**RE: Shoalhaven Starches Pty Ltd – Modification of MP06\_00228 (Mod1) – Removal of DDG Pelletising Plant from Mandatory Odour Controls.**

Figure 4 - Elevation showing bottom fill load chute

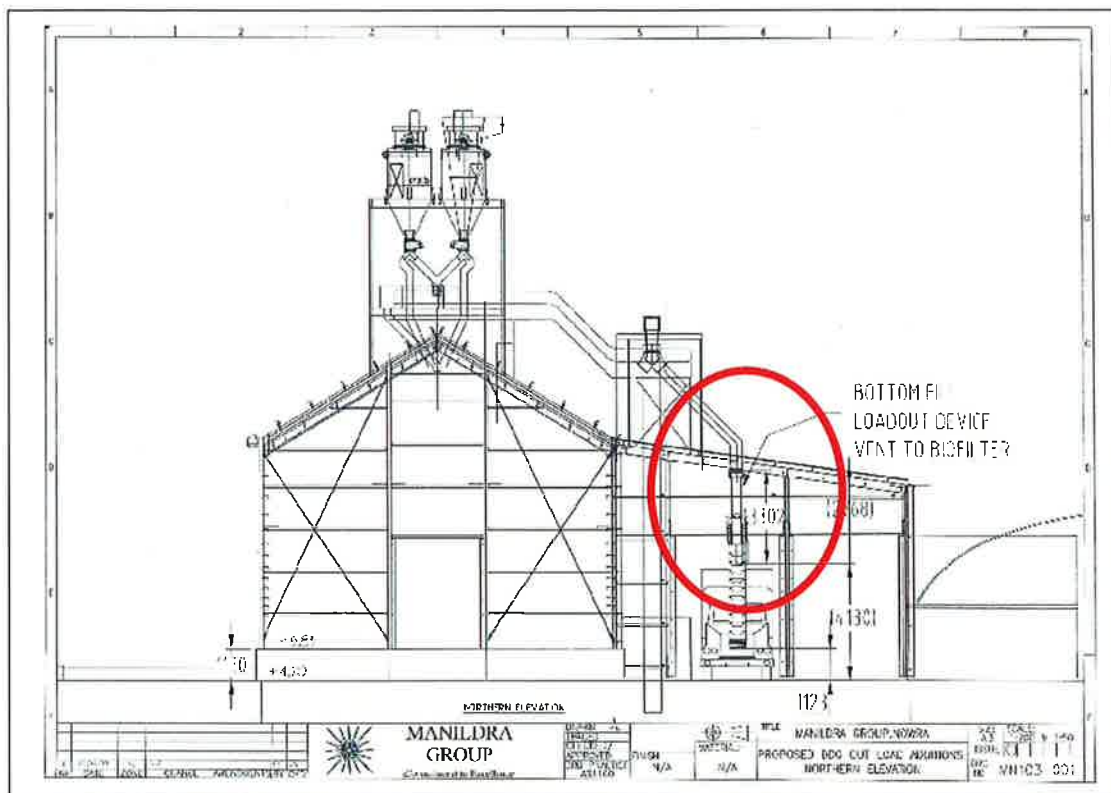
1. Direct all air emissions from the Palmer Cooler stack to a boiler for odour destruction; and
2. Extend the length of the existing DDG product load out awning, install motorised roller doors to each entry end and fit Moduflex Bellows Feeders chutes for loading DDG product with a fugitive dust extraction arrangement that directs air captured during loading operations to the biofilter for odour treatment.

Figure 5 - Plan showing extension to southern awning of load-out shed

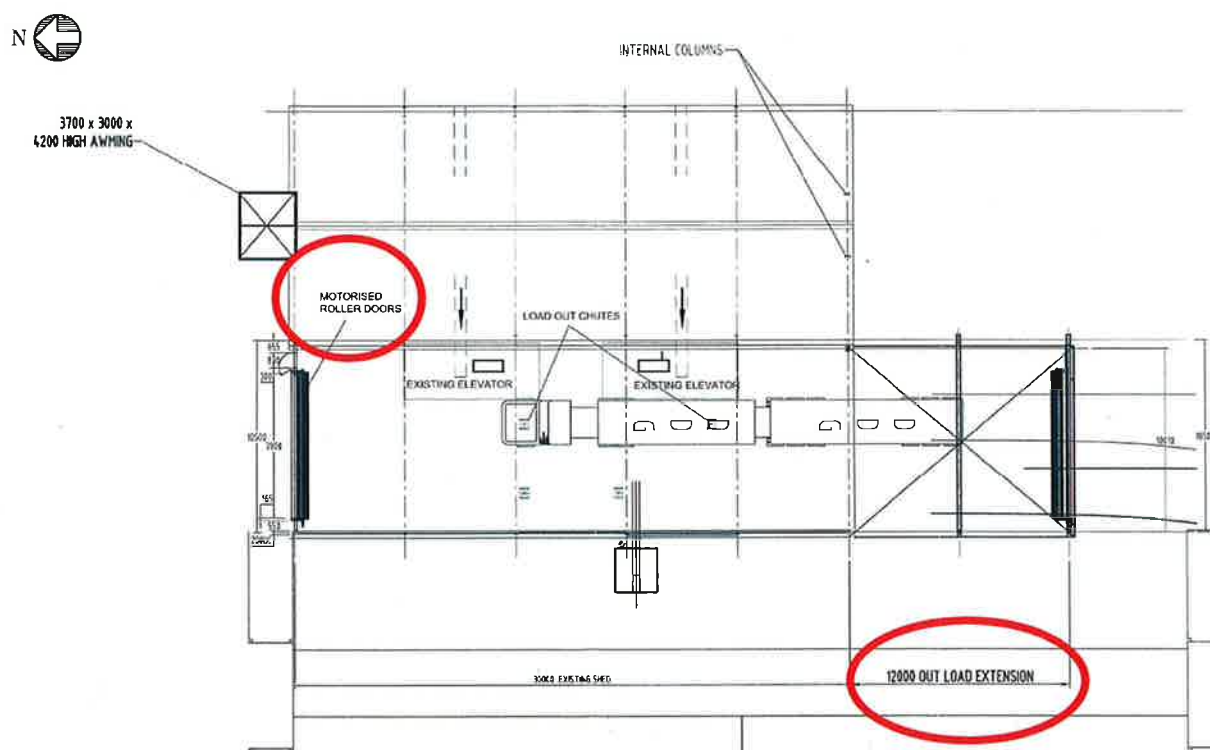
1. The biofilter system design and operation shall be reviewed to demonstrate that it can adequately remove the odours associated with the DDG product storage shed.
2. The DDG product storage shed shall be fully enclosed and an air extraction system installed that directs the air to the biofilter system. The biofilter system shall be designed and maintained so that it removes odours from the DDG product storage shed.
